## REVIEW RESPONSE

**DATE: 4/4/2022**

**PROJECT NAME: AMIGA PIER**

**RESPONSE TO: SHL21-041 / SEP21-026 REQUEST FOR INFORMATION**

SHEET
A5.0

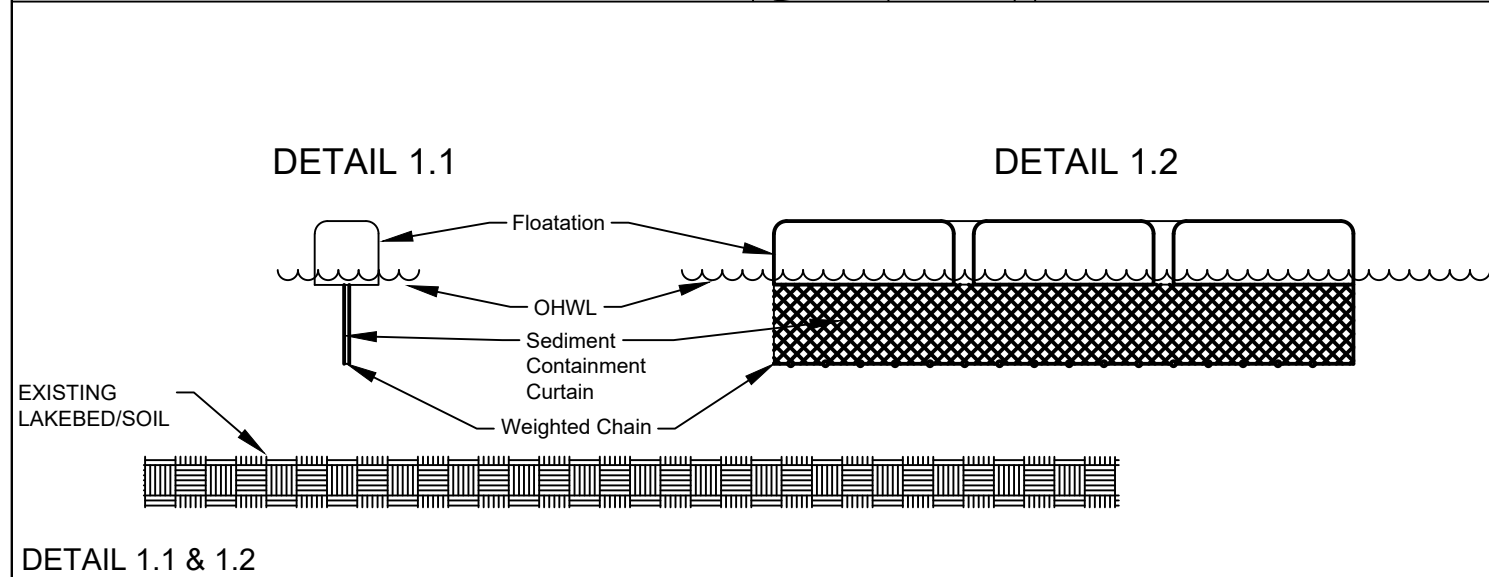
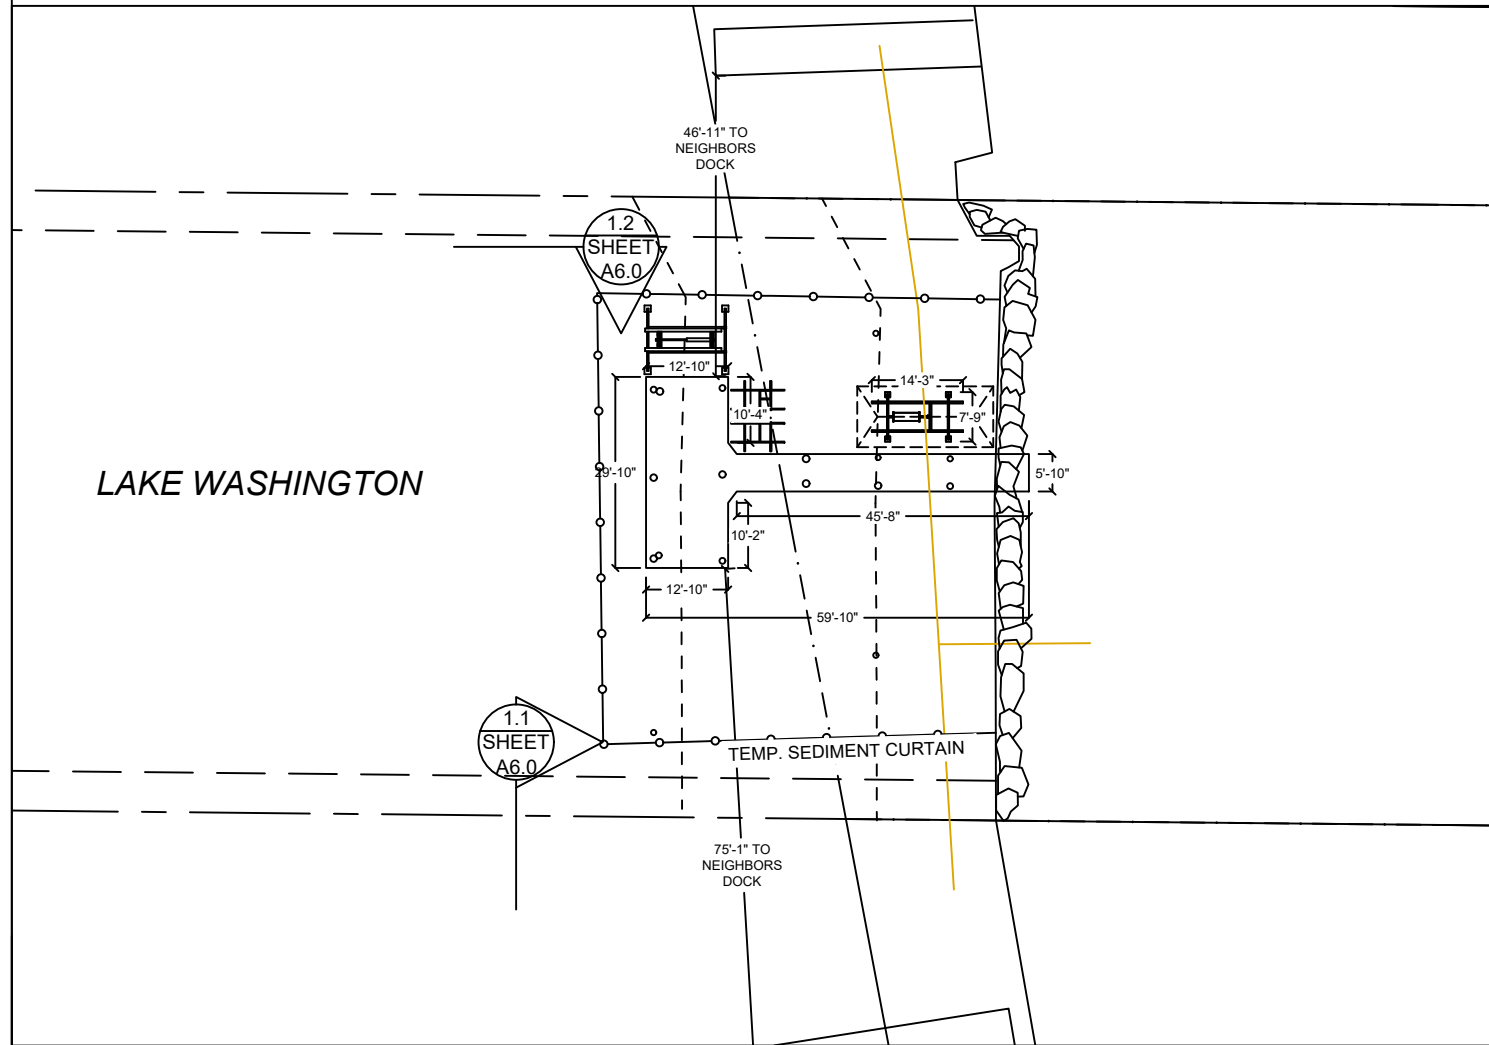
2. Please provide the following information on the pier elevations:

a. Please show all moorage piles on the pier elevation. Please also show the heights of the piles above the OHWM on the elevation.

**Please see Sheet A5.0 of updated plan set.**

SHEET
A4.0

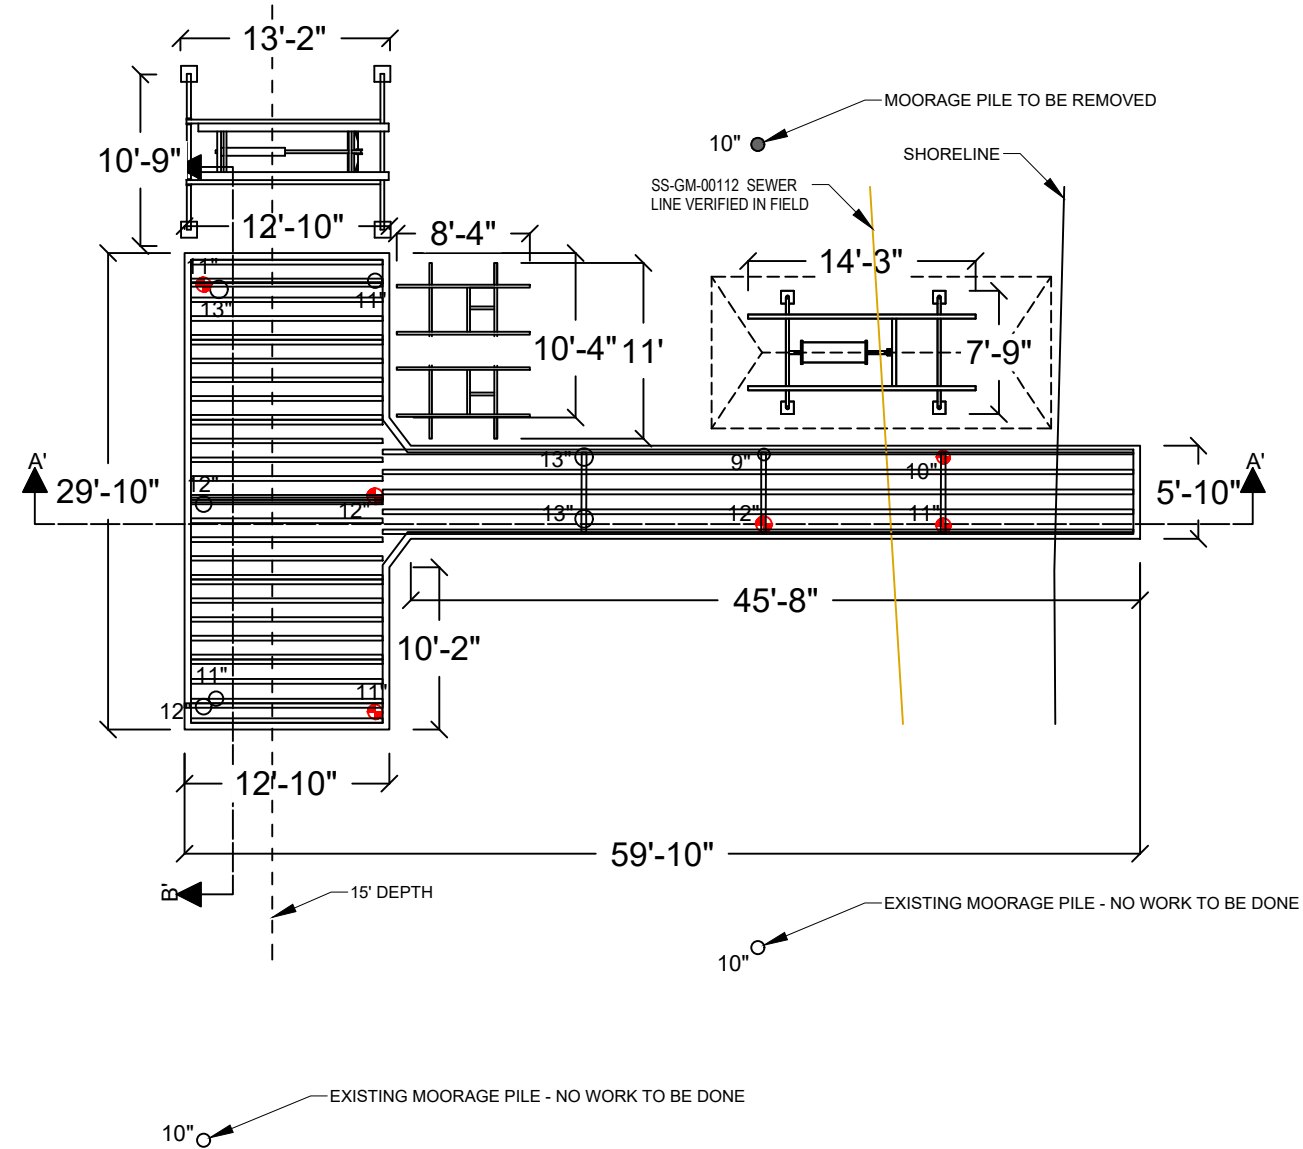
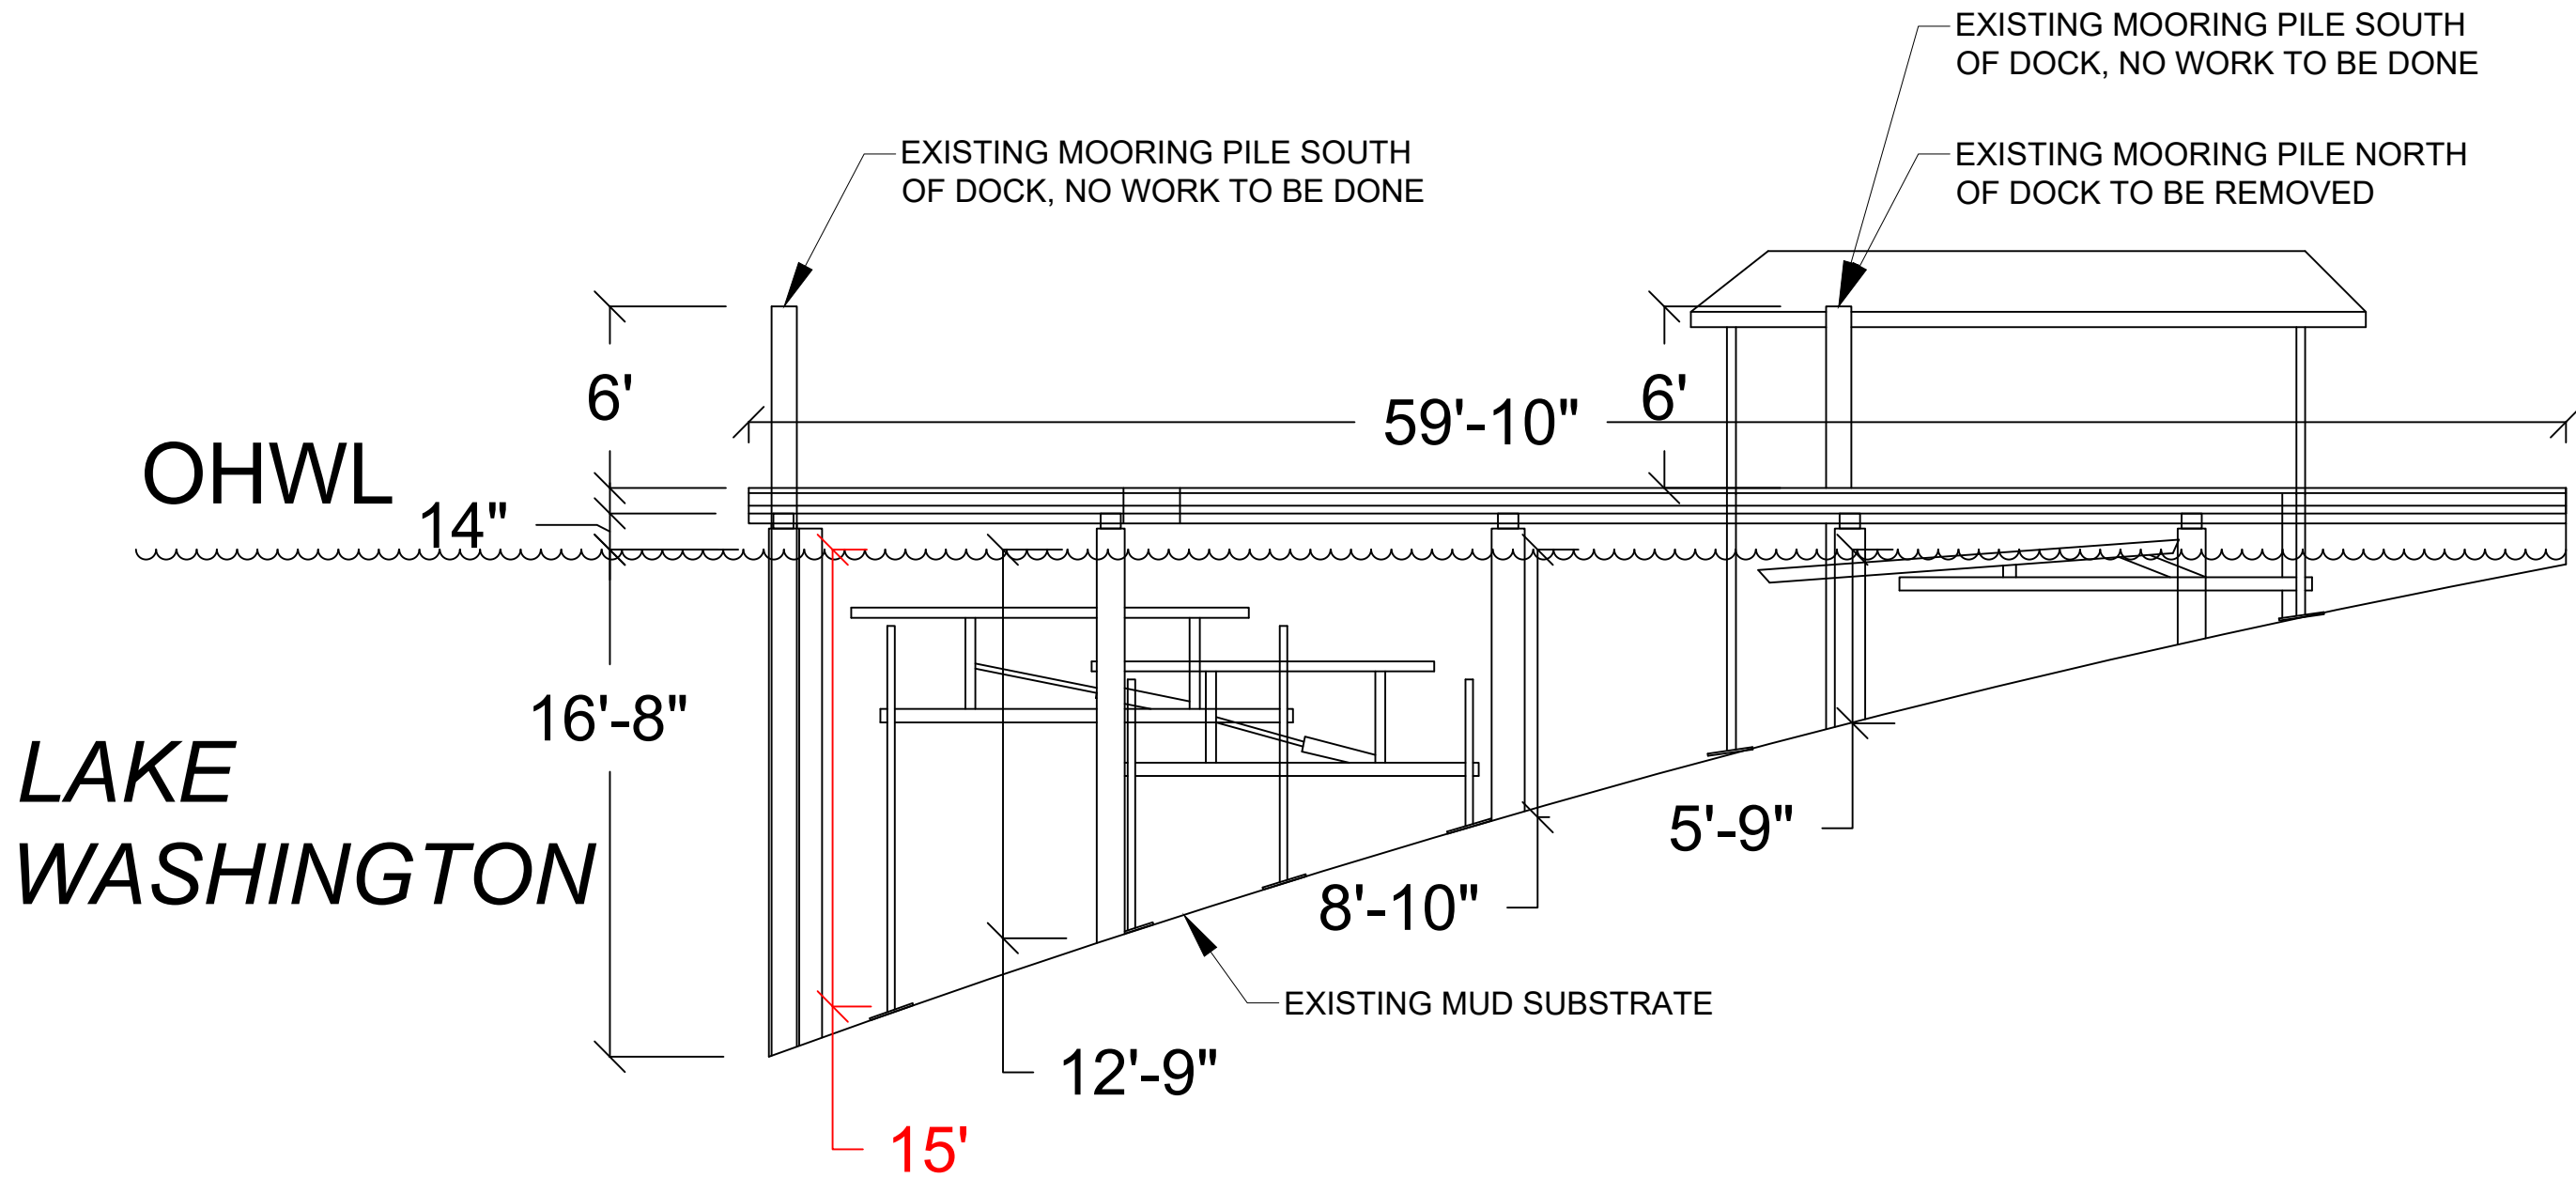
Please provide an accounting of all the framing elements, including, but not limited to, stringers, piles, pile caps, and attachment brackets, that are proposed to be repaired or replaced as a part of this proposal. Please also demonstrate that the total number of framing elements to be replaced does not exceed the 50% threshold of MICC 19.13.050(F)(2)(ix) is being exceeded. If the 50% threshold is being exceeded, please provide revised plans that show compliance with MICC 19.13.050(F)(2)(ix)(a) through (c).

**Project should be evaluated under 19.13.050(F)(3).**
